Norwich to Tilbury Deadline 1 Submission

Respondent: Newlands Partnership & Messrs Watkinson, Whitley
and Steward

Property: NK332995

Figure 9.3 - Contaminated Land, Geology and Hydrogeology - Mineral Safeguarding Areas, Mineral Consultation Areas and Mineral Infrastructure

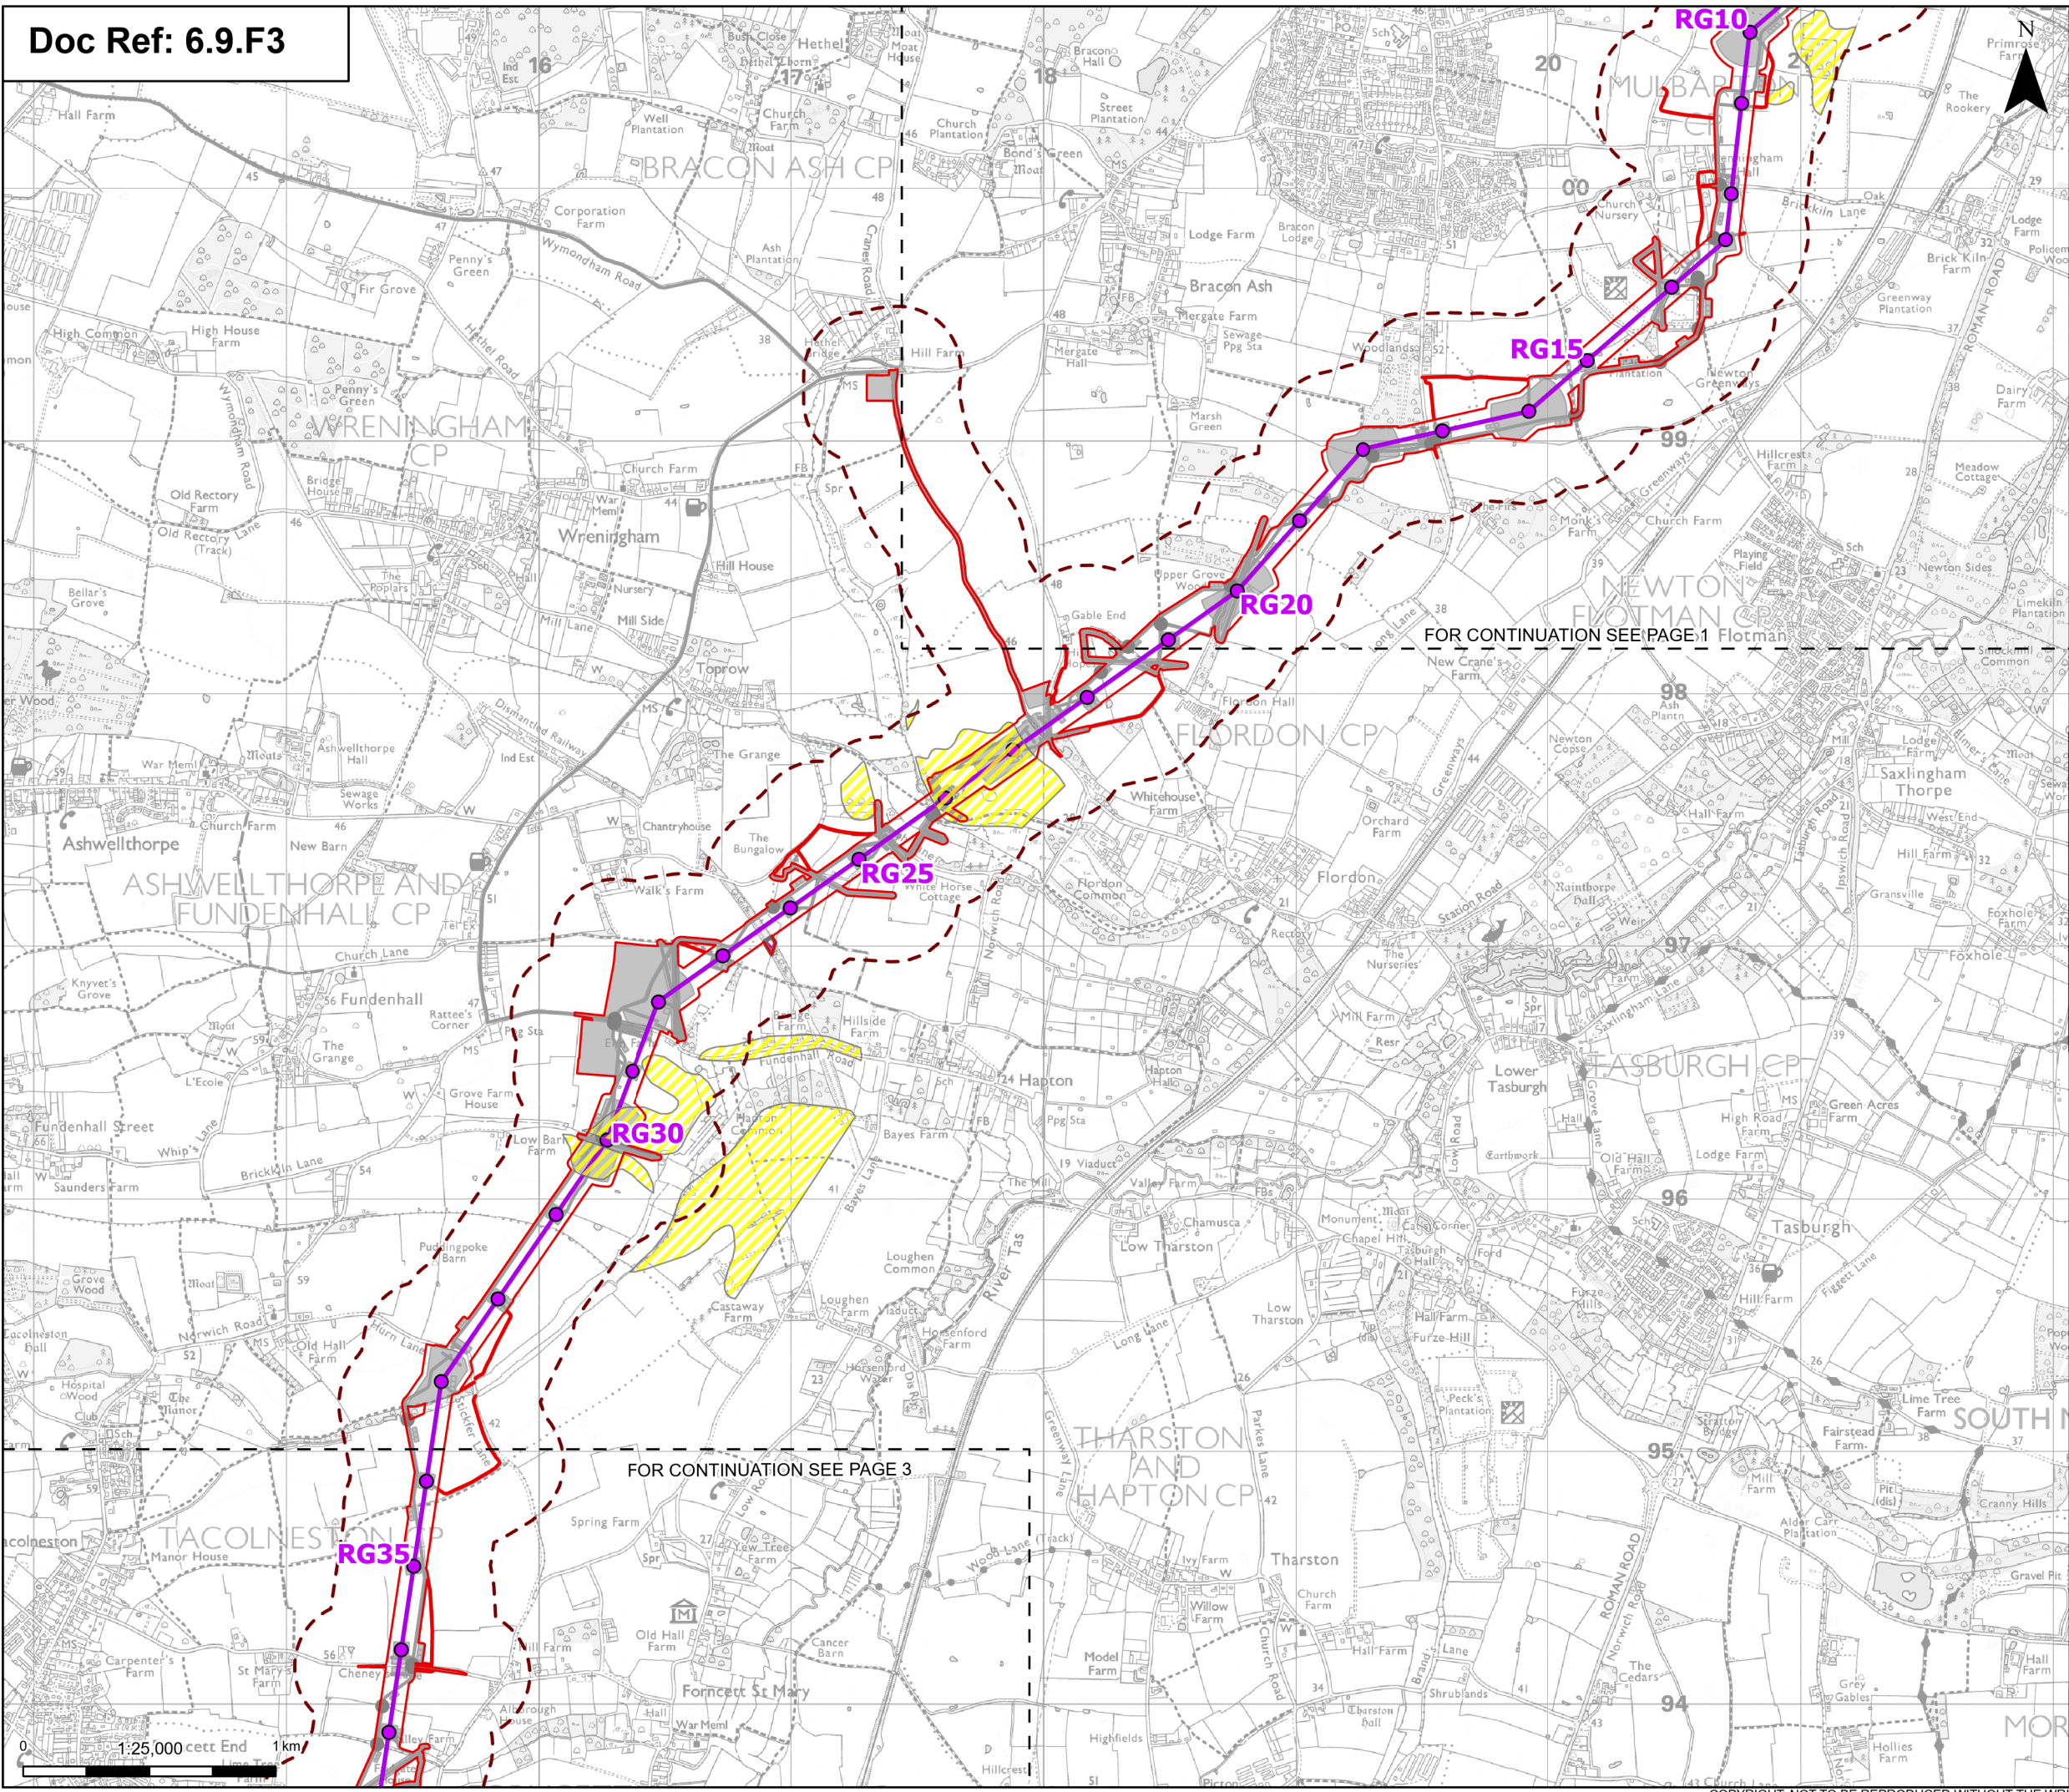
The area filled yellow was previously designated as Site Min79 in the Norfolk Minerals Plan. That allocation lapsed, by landowners' choice, and the land was not put forward for the current Minerals and Waste Plan.

A 2003 geological survey estimated that the main mineral reserve, being the area with the yellow hatching, held 1.76 million tonnes of gravel and would leave a void of 600,000 cubic meters to use for inert fill.

The current owners desire to not advance this project does not mean that the reserves should not be preserved for future use.

Pylons RG03, RG04 and RG05 should be moved closer to the edge of parcel to minimise the volume of minerals their construction will sterilise.
